**PRELIMINARY DRAINAGE REPORT**

**THE RETREAT AT TIMBERRIDGE  
PRELIMINARY PLAN  
(SOUTH OF ARROYA LANE)**

**SP-18-002**

**PRELIMINARY DRAINAGE REPORT FOR  
THE RETREAT AT TIMBERRIDGE PRELIMINARY PLAN  
(SOUTH OF ARROYA LANE)**

THE RETREAT AT TIMBERIDGE
PRELIMINARY DRAINAGE REPORT
(SOUTH OF ARROYA LANE)
DEVELOPED DRAINAGE MAP

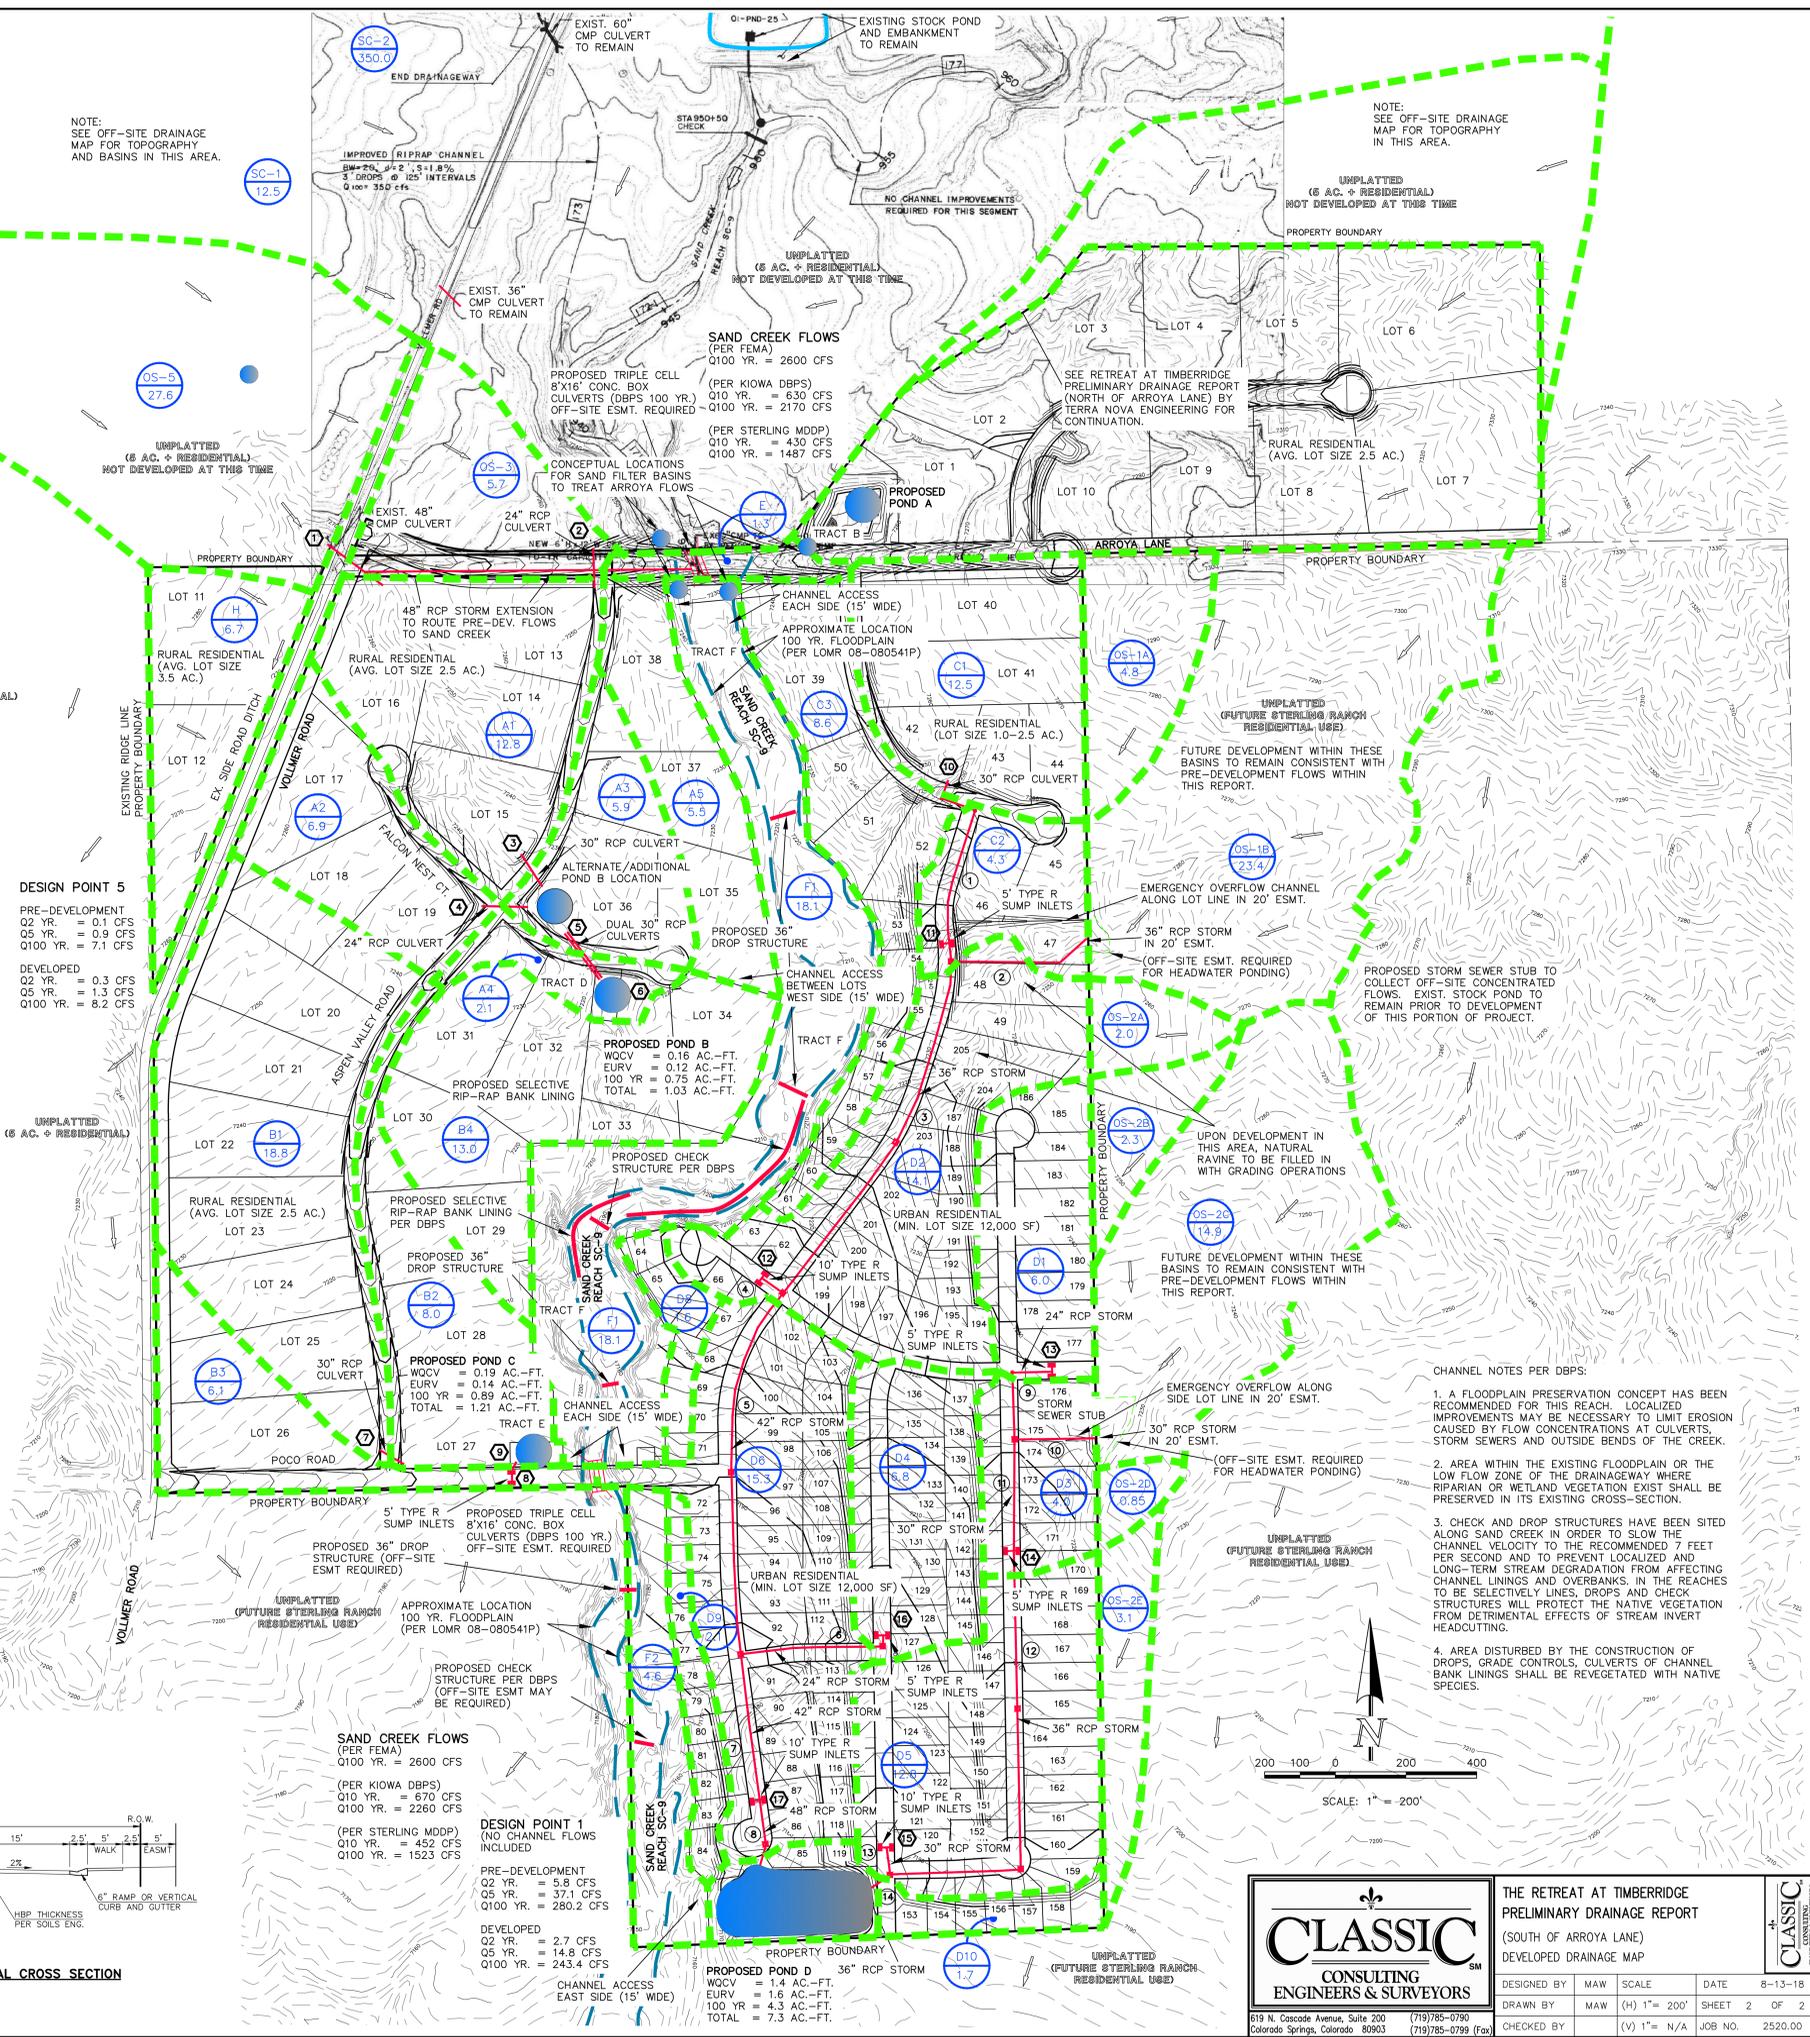
Address basin E  
including WQCV

WQCV is required prior to flows  
entering waters of the state.
